Harnett County Government Complex
307 W. Cornelius Harnett Boulevard
Lillington, NC 27546

Kicking Camel
174 N. McKinley St.
Coats, NC 27521

Re: Plan Review Kicking Camel

PLAN

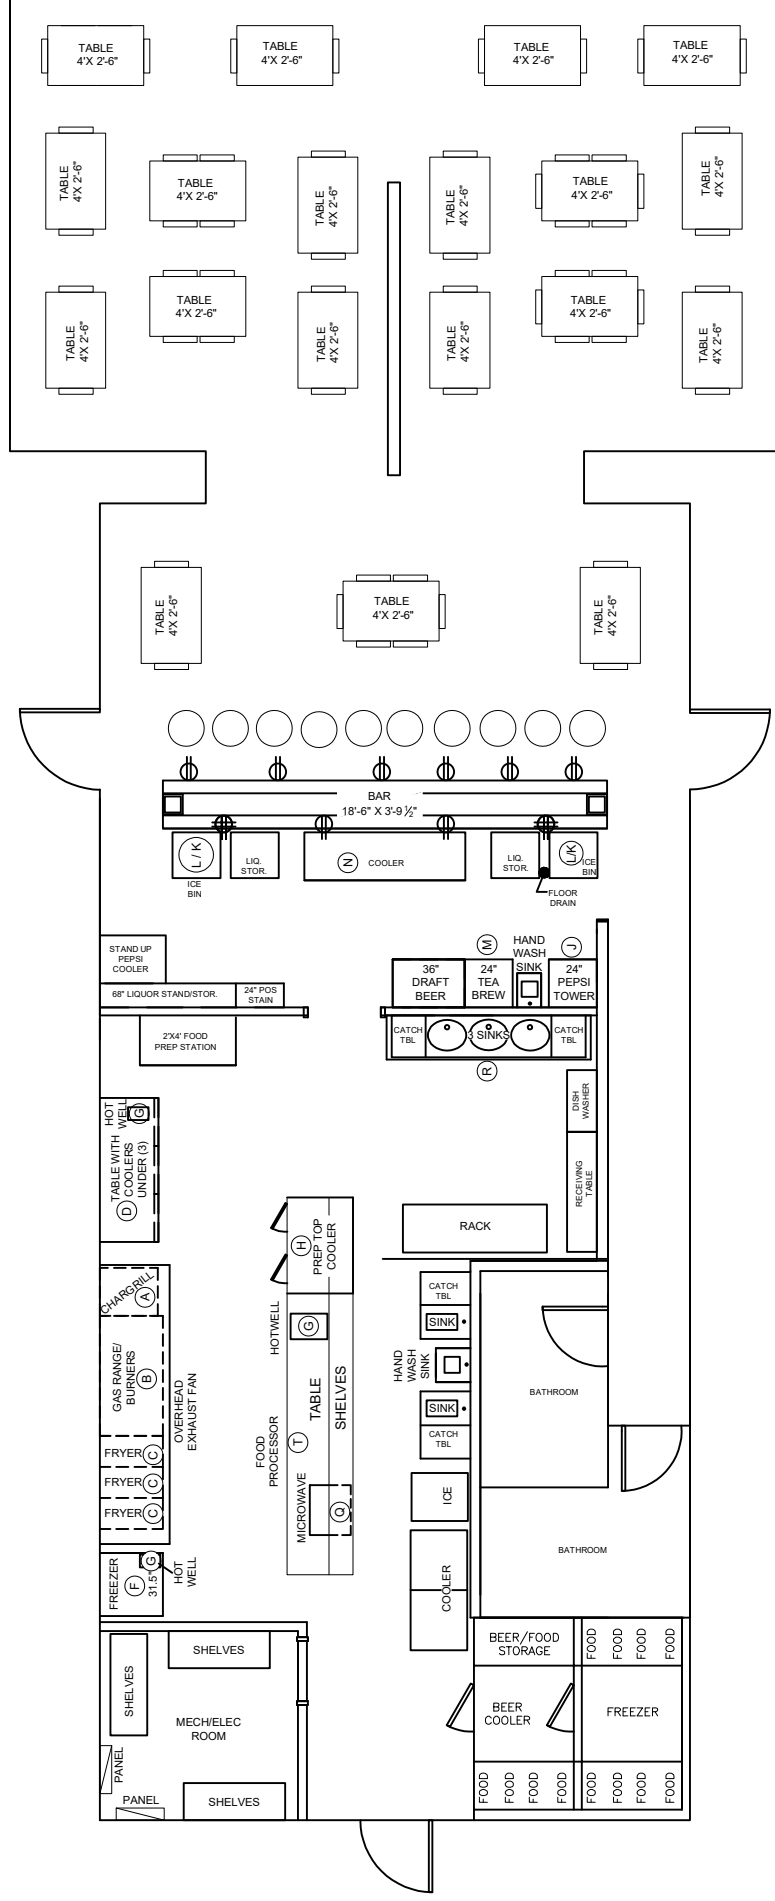
Thank you for the submittal of the information last week. I've reviewed all the information submitted pertaining to the plan review for the Kicking Camel Grill. While I have received drawings and pictures of the kitchen and bar, I do not have a site plan to scale of the entire kitchen, bar and seating areas. Due to changes in the layout of equipment, a constructed full bar, changes in seating, and proposed use of the detached building, it is required by the Rule .2658 Compliance and Enforcement that plans drawn scale for independent food establishments shall be submitted for review and approval of the local health department. Plumbing and electrical work done, but not permitted or inspected by Building Dept. will hold up a permit from Environmental Health. Submit the site plan to scale to Donna Johnson at Central Permitting. Additional copies of the site plan may be required for Building and Fire. Call Donna with questions pertaining to permits required for electrical and plumbing. I have discussed the need for a handsink in the bar area with our State Regional Specialist, Thomas Jumalon and he agrees a handsink in the bar is required. The full bar is in a separate room from the single kitchen handsink, which is located towards the back of the kitchen. The single kitchen sink is conveniently located for cooks and food handlers. The wait staff and bartenders need a handsink in the bar area that is easily accessible. In addition, the dispensing of ice and changing tasks from handling soiled glassware to clean would require a handwashing step. 5-204.11 Handwashing sinks-A handwashing sink shall be located (a) to allow convenient use by employees in food preparation, food dispensing, and warewashing areas. The detached building was proposed for use of reach in refrigeration and storage. Additional refrigeration is required to replace food storage area lost in the cooler. Cooler drawings show different areas designated for food storage in the cooler. One drawing shows food and kegs on the left side and right side of the cooler, the other shows kegs on the left and food on the right. Clarify this on a site plan drawn to scale. Specify use for the exterior building, provide a site plan to scale with finishes indicated, and any equipment located in building. Is the bar already constructed? If so, provide pictures along with the site plan. Did the glycol system require hard wiring or plumbing work?
